SSD-10269: Lot 152 DP 816020 and others; 10 Kurrajong Creek Road, Baan Baa Narrabri Underground Mine Stage 3 Extension Project – Submissions Report

Thank you for the referral of SSD-10269 via the SW Major Project Planning Portal dated 2 June 2021 inviting comment from Transport for NSW (TfNSW) in relation to the latest SSD-10269 Submissions and Amendment reports.

Job No. : N4957
Client : TTPP
Suburb : Narrabri
Location : 1. Kamilaroi Hwy / Kurrajong Creek Rd

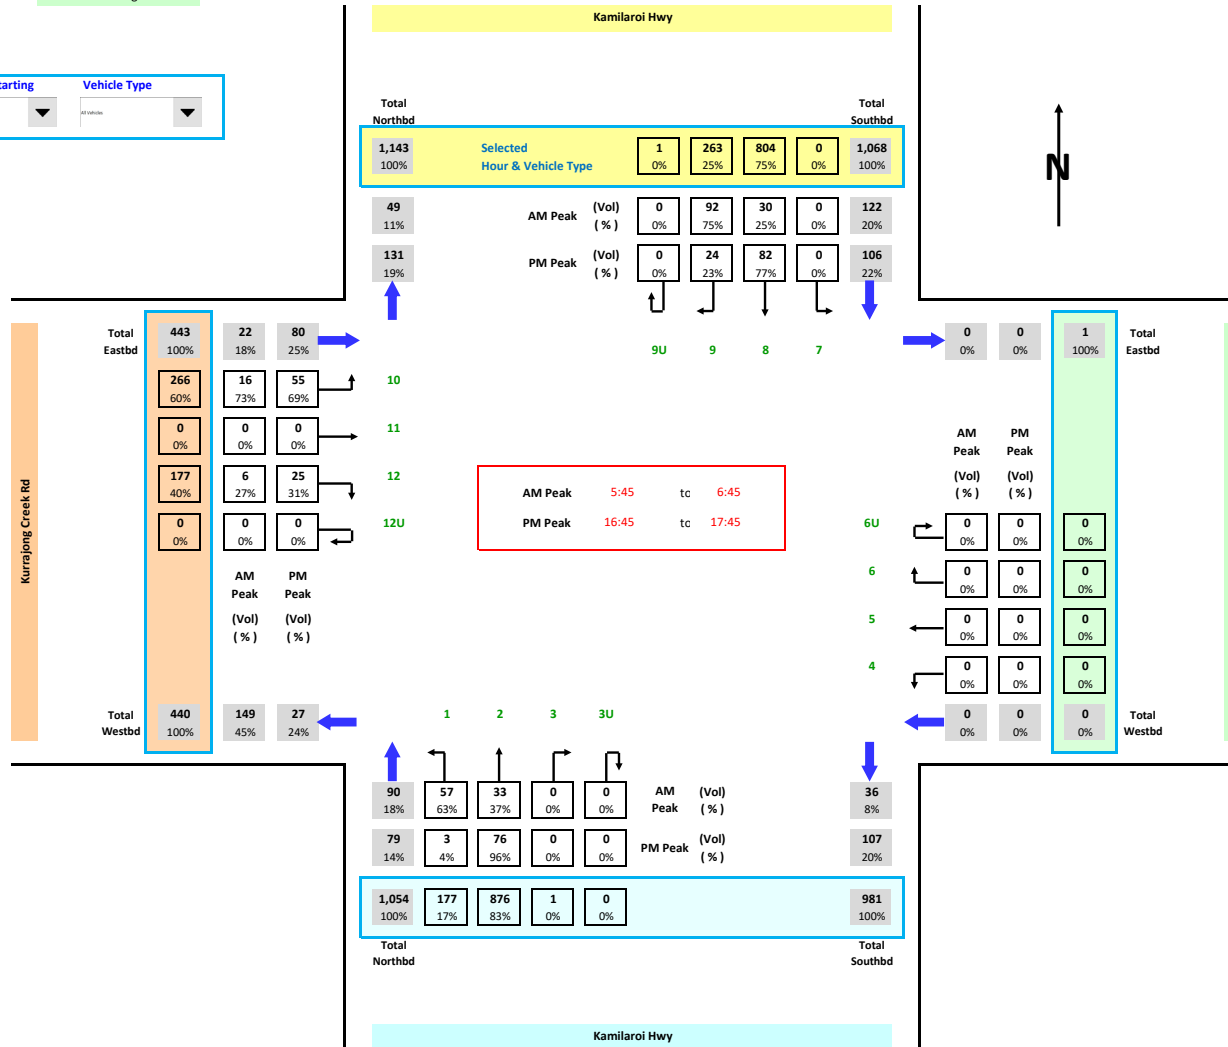
- The applicant should provide an assessment and recommend improvements to existing arrangements to mitigate the risk of vehicle-train collision.
- An assessment of the of the Kurrajong Creek Road Kamilaroi highway intersection is to be conducted to determine compliance with Austroads design requirements at the proposed traffic volumes.

- Please confirm the design vehicle (largest vehicle) accessing the site and provide swept path drawings demonstrating the design vehicle can safely turn in all four directions at the intersection of Kurrajong Creek Road with the Kamilaroi Highway. If upgrades would be required to safely cater for movements, specify the maximum truck size(s) sought under this SSD application and/or the recommended extent of upgrade works.
